# TRAFFIC IMPACT ASSESSMENT (TIA)

**Proposed Waste Management facility  
2-4 Hale Street, Botany**

Reference: 23.464r01v13  
Date: March 2025

This revised TIA has been prepared to accompany an amended SSD application to address comments concerning the proposal from Department of Planning, Housing and Infrastructure (DPHI) as contained in a letter dated 13 September 2024 (DPHI Reference: SSD-62855708), and Bayside Council as contained in a letter dated 9 September 2024 (Council Reference: SSD-2024/10).

Drawn: AB	Checked: TY	Date: 04-12-24
23.464d01v11 TRAFFIX [241204 Plans] Design Review JP.dwg		
Project No. 23.464	Drawing Phase RFI	Drawing No. TX.05
Rev. A

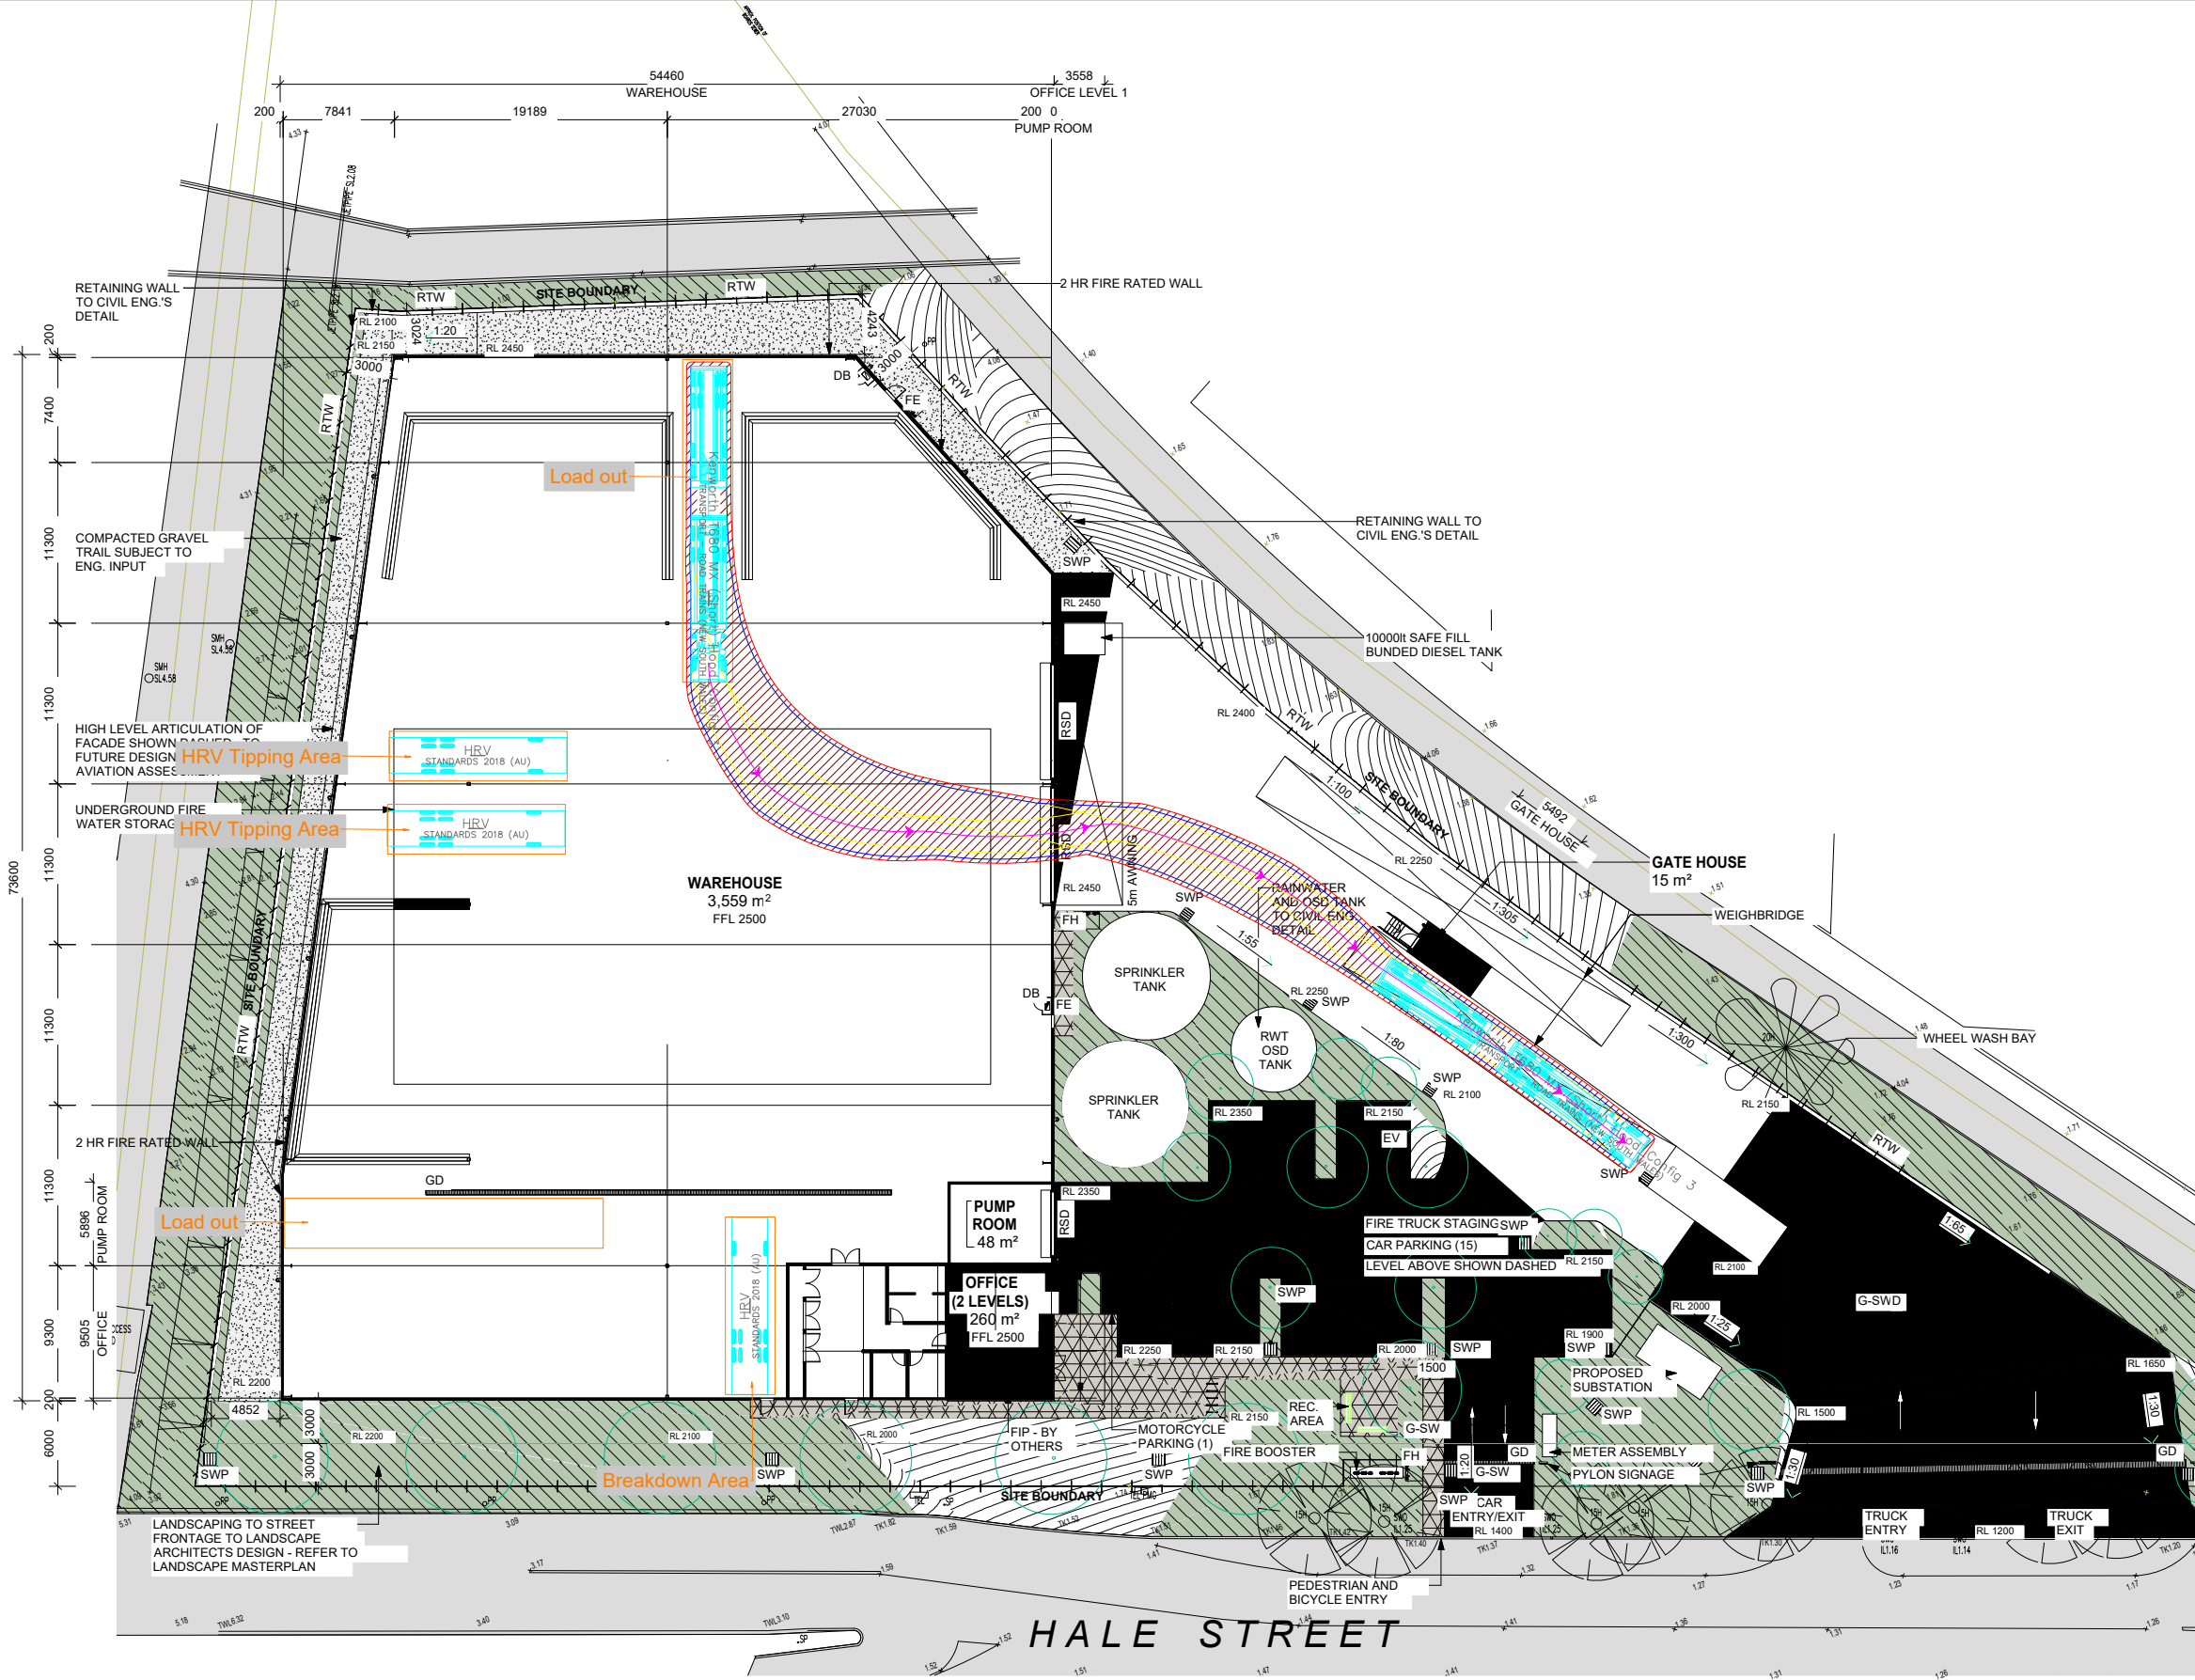
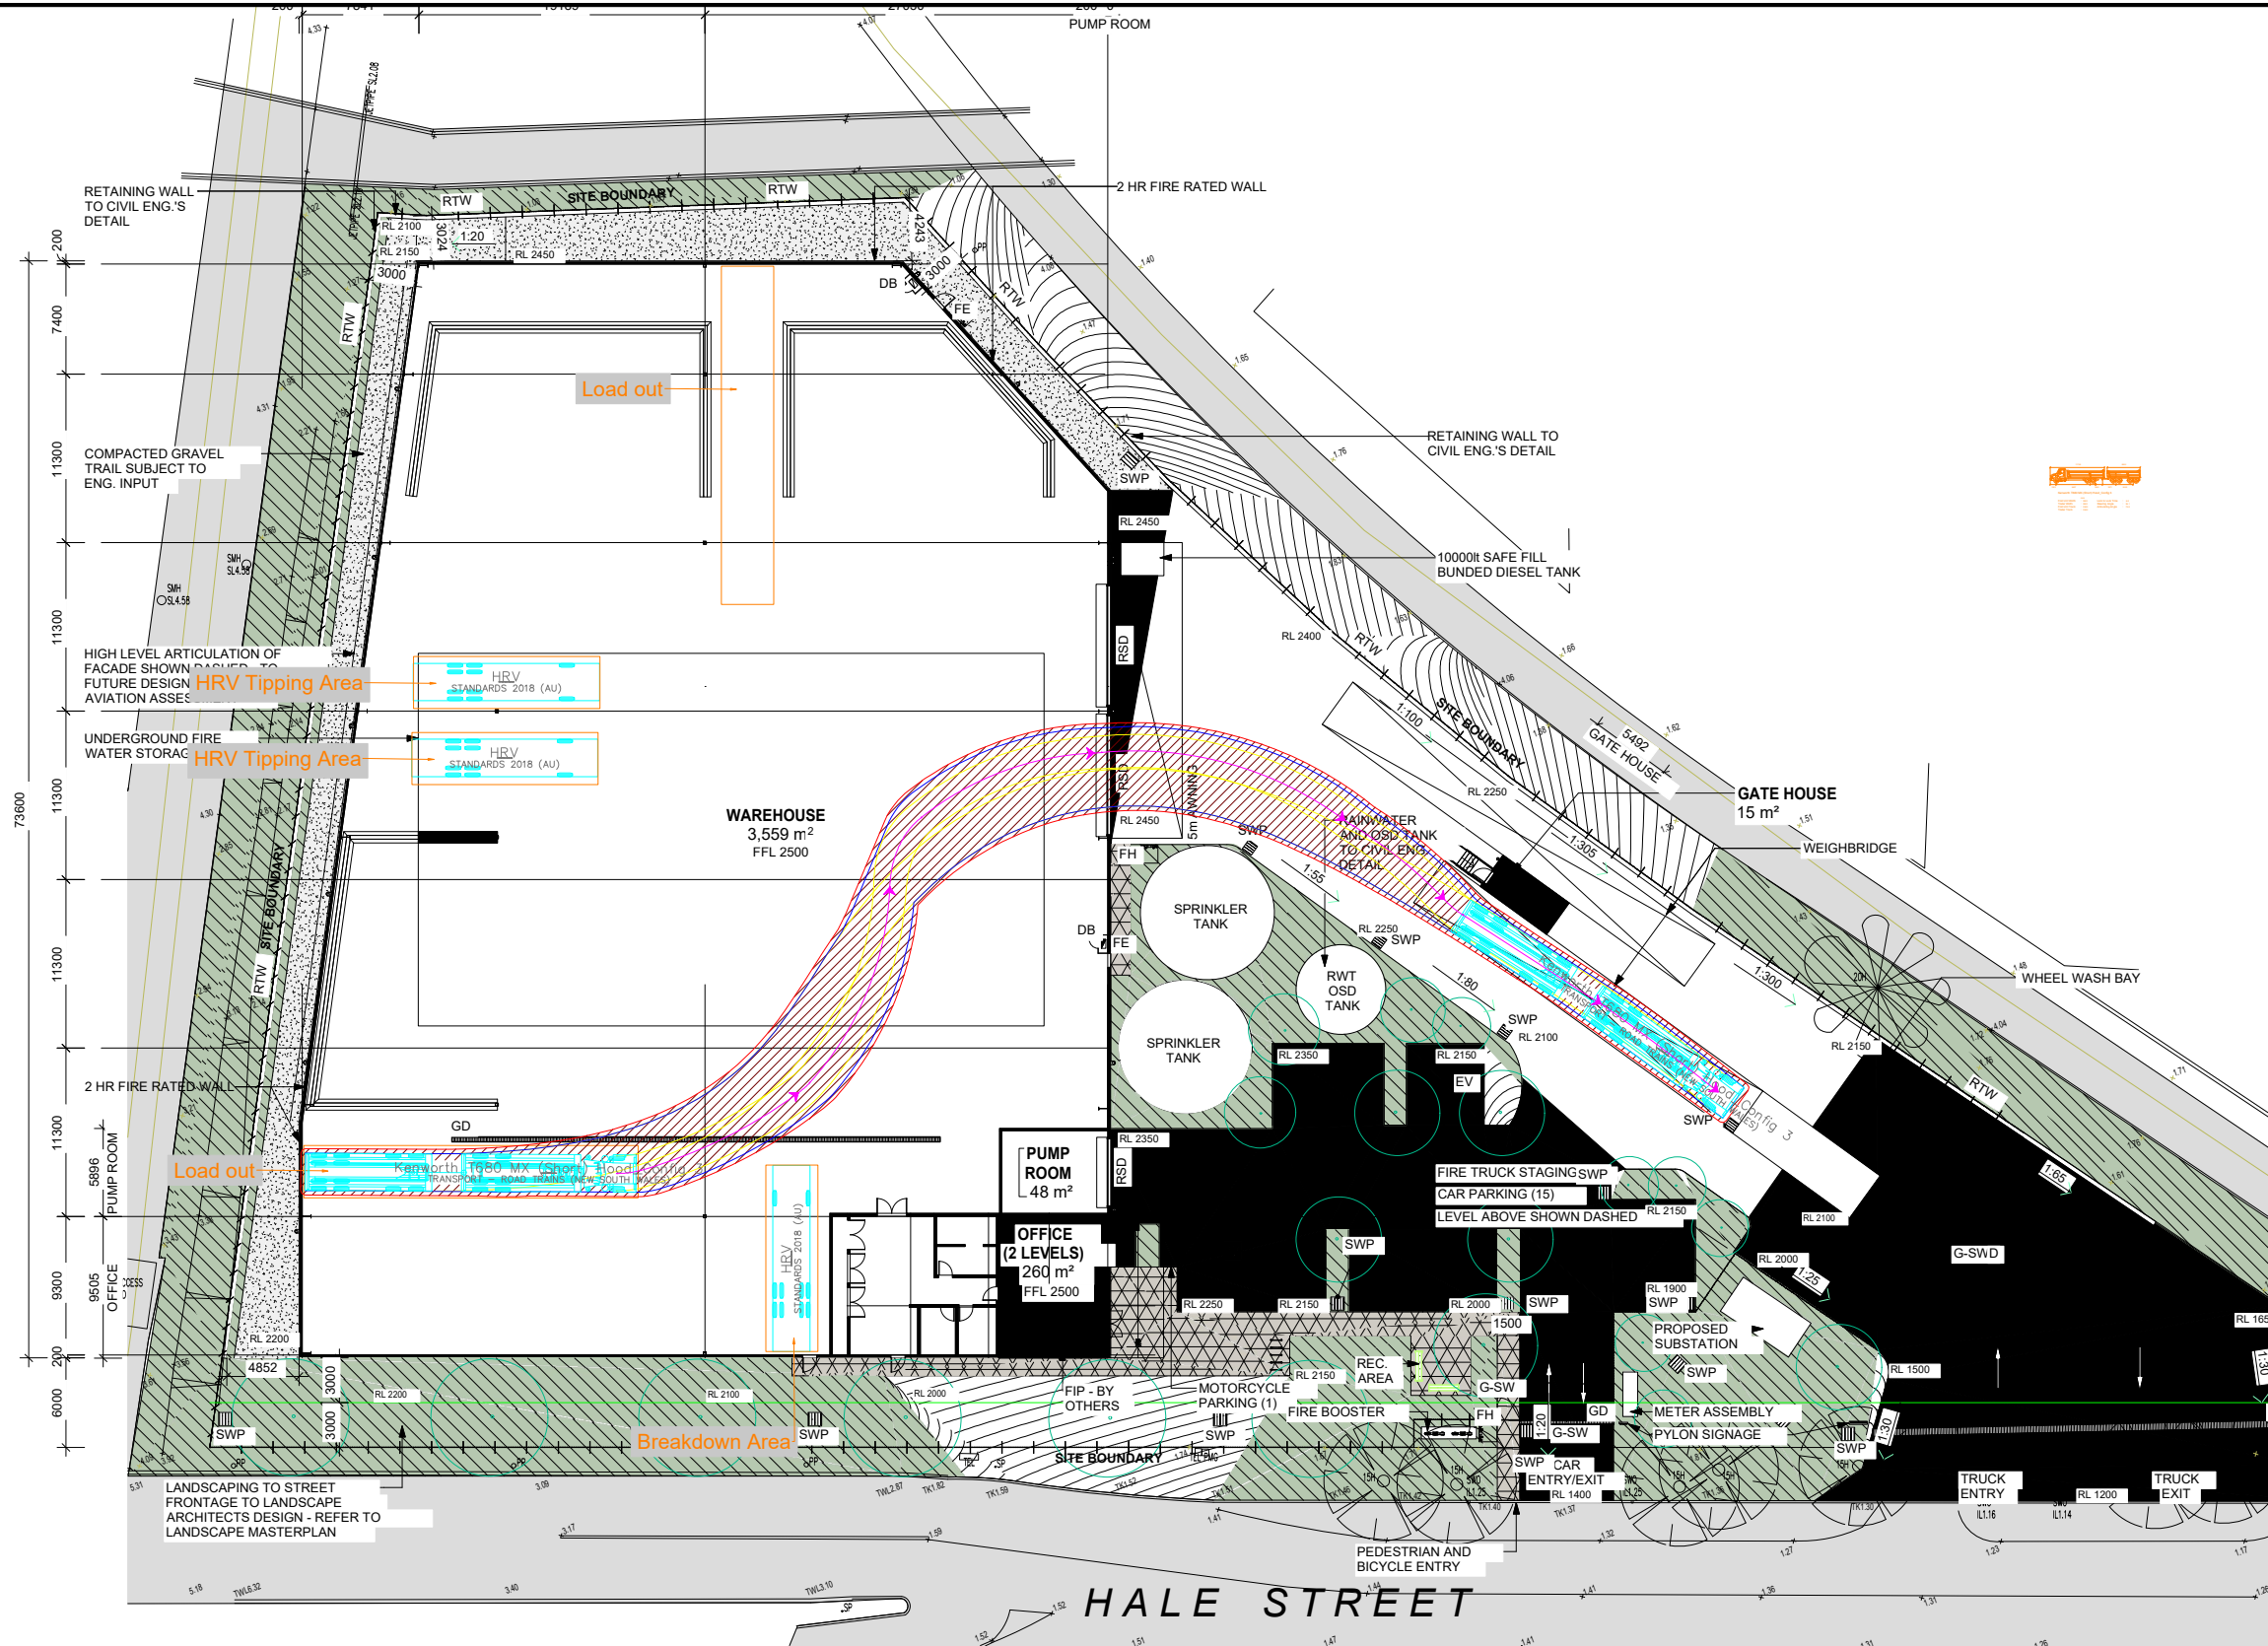
<p><b><u>Swept Path Analysis</u></b></p> <p>The swept path analysis for the site access driveway provided at Appendix D of the TIA is unclear and indicates there may be conflict between two B-doubles travelling eastbound and westbound on Hale Street.</p> <p><b>Recommendation: Revised swept path analyses are required for 20 metre articulated vehicles and B-doubles accessing the site that clearly demonstrates the centreline of Hale Street will not be crossed and there will be no conflict with on-street parking. All line marking on Hale Street must be clearly marked.</b></p>	<ul style="list-style-type: none"> <li>• Swept path analysis have been updated with recent Nearmap aerial georeferenced in the background clearly demonstrating 26m B-double vehicles will be able to ingress and egress the site satisfactorily in accordance with AS 2890.2 (2018).</li> </ul>
<p><b><u>Daily Heavy Vehicle (HV) Movements</u></b></p> <p>Section 6.10: Truck Frequencies of the TIA outlines the anticipated truck volumes for the development. It is not clear how these vehicle numbers have been determined. Bayside Council has also raised several queries regarding the traffic generation analysis.</p> <p><b>Recommendation: Additional information is required to justify the predicted truck volumes, including the breakdown of vehicle types.</b></p>	<ul style="list-style-type: none"> <li>• TIA has been updated to provide detailed calculations on how the anticipated heavy vehicle trip generation associated with the proposed development has been estimated including a breakdown of the vehicle types, refer to <b>Section 9</b>.</li> </ul>

<p>The appendix D swept path analysis details an unrealistic kink in the truck wheel movement near the car entry/exit. See figure below.</p>	<ul style="list-style-type: none"> <li>All swept path analysis has been undertaken using the latest version of the industry leading software AutoTURN Pro, we can provide animated swept paths in a video file or live demonstration to Council upon request to prove our professional integrity.</li> </ul>
<p>The swept path analysis shall be revised to better depict all line marking on Hale Street. Vehicles shall not cross over the road centreline.</p>	<ul style="list-style-type: none"> <li>Swept path analysis have been updated with recent Nearmap aerial georeferenced in the background clearly demonstrating 26m B-double vehicles will be able to ingress and egress the site satisfactorily in accordance with AS 2890.2 (2018).</li> </ul>
<p>The parking rate derived in section 7 of the traffic report is insufficient for this site. 1 car parking space shall be provided for each staff member in addition to the 4 visitor spaces. Additionally, given the swept paths and the two driveways proposed, the on- street parking on the northern side of Hale Street is effectively entirely removed by this development. The loss of public parking needs to be supplemented by the development.</p>	<ul style="list-style-type: none"> <li>The proposed development has been amended to provide a minimum of one (1) car parking space per FTE staff in addition to the four (4) visitor spaces in accordance with Council's request.</li> <li>It is unclear how on-street parking can be supplemented by a private development that is not open to the public notwithstanding the security and legal challenges if this was permitted to occur.</li> <li>Refer to <b>Section 8.6</b> of this report.</li> </ul>
